Address: 18 Woodhead Road Holmfirth hd9 6pp

Application number: 2023/90444	
What is the application for?:	Erection of detached dwelling
Address of the site or building:	Land adj, Fern Bank, Far End Lane, Honley, Holmfirth, HD9 6NS
Postcode:	HD9 6RP

North Elevation - 1:100

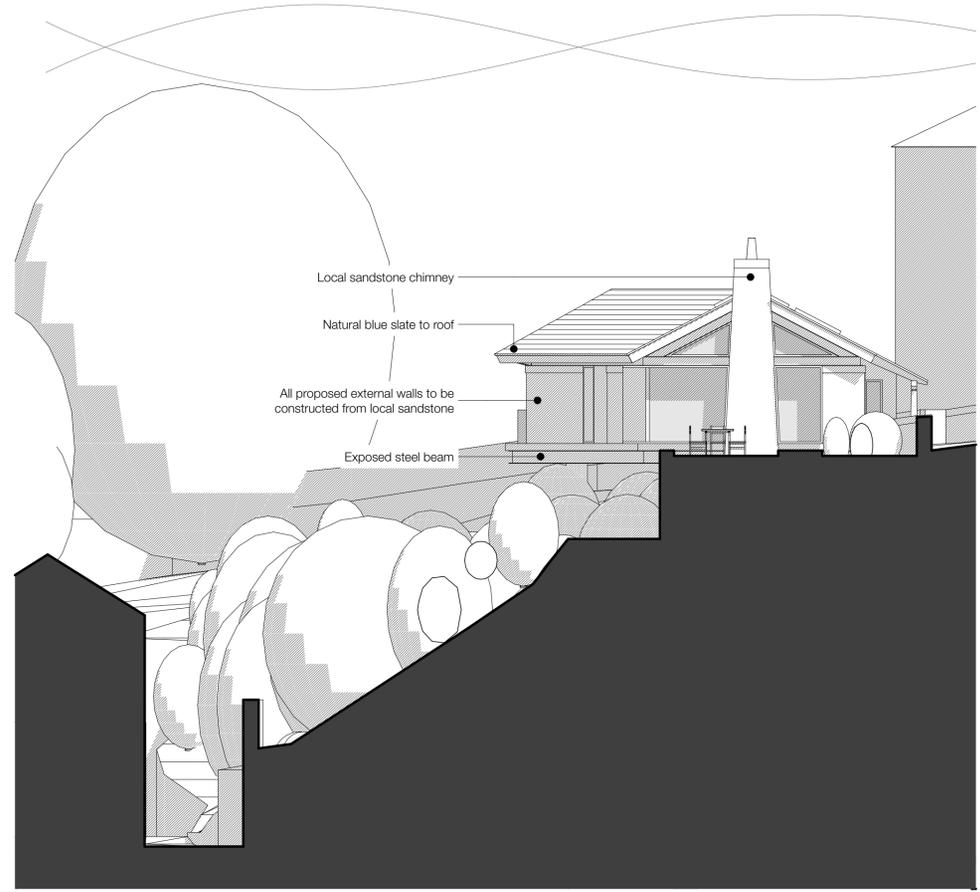
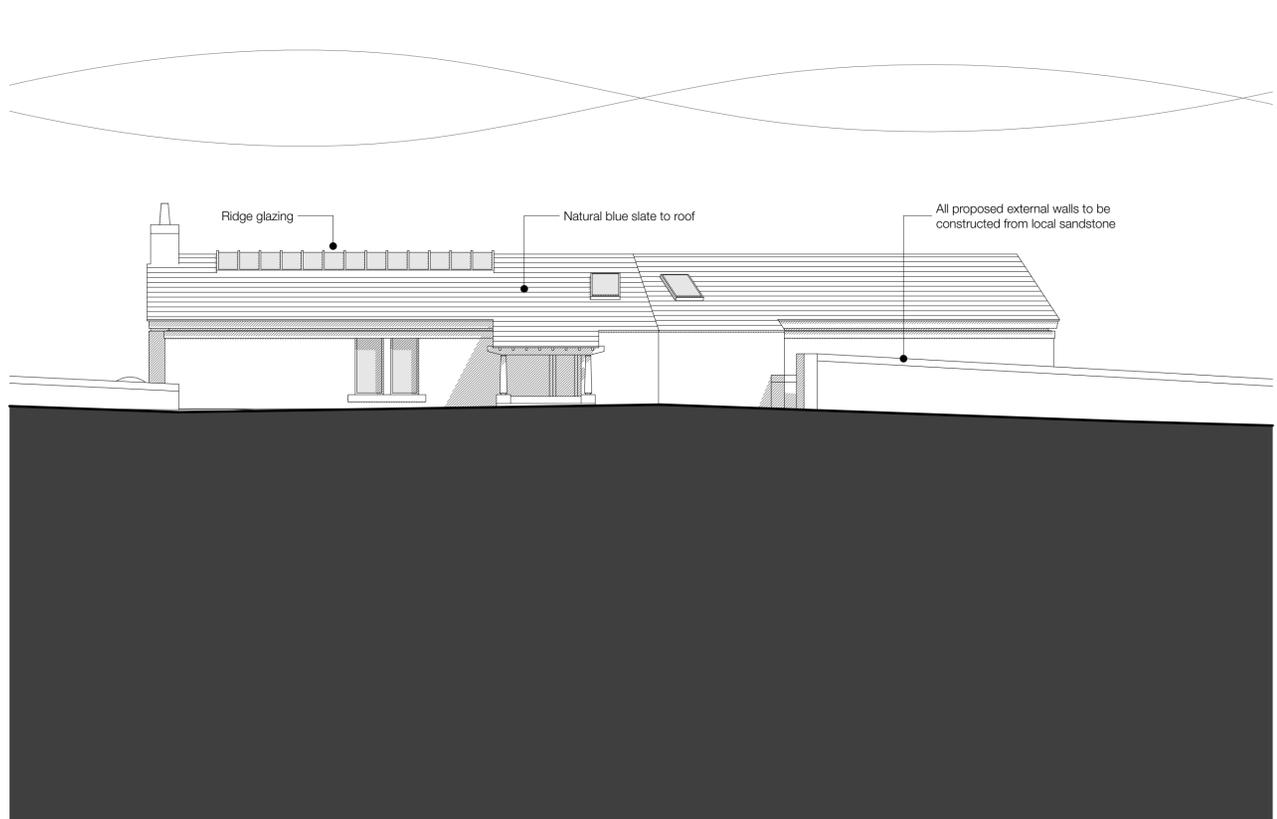
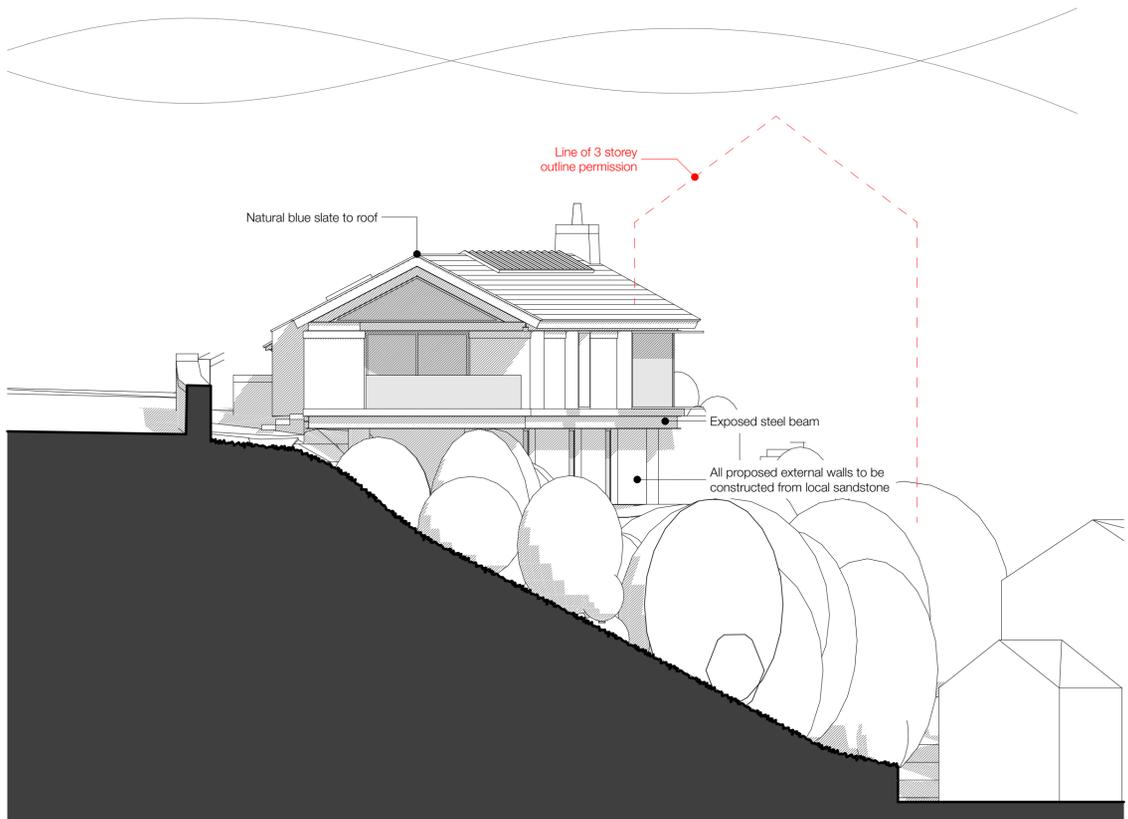
Type of comment: An objection	
Do you wish your comments to be published on the website anonymously?	No
<p>The 'Proposed Elevation' plan - Drawing 3479 (0-) 11 Rev B shows a 'North Elevation' which is the view from Woodhead Road.</p> <p>There is an obvious omission from this view - the property below 18 Woodhead Road.</p> <p>Can we please ask the Planning Officer to request that no18 is shown on this plan on the North Elevation and provide opportunity for comment thereafter.</p> <p>The impact of the proposed dwelling on the neighbouring property, 18 Woodhead Rd, cannot be properly and fairly considered if this is not provided.</p>
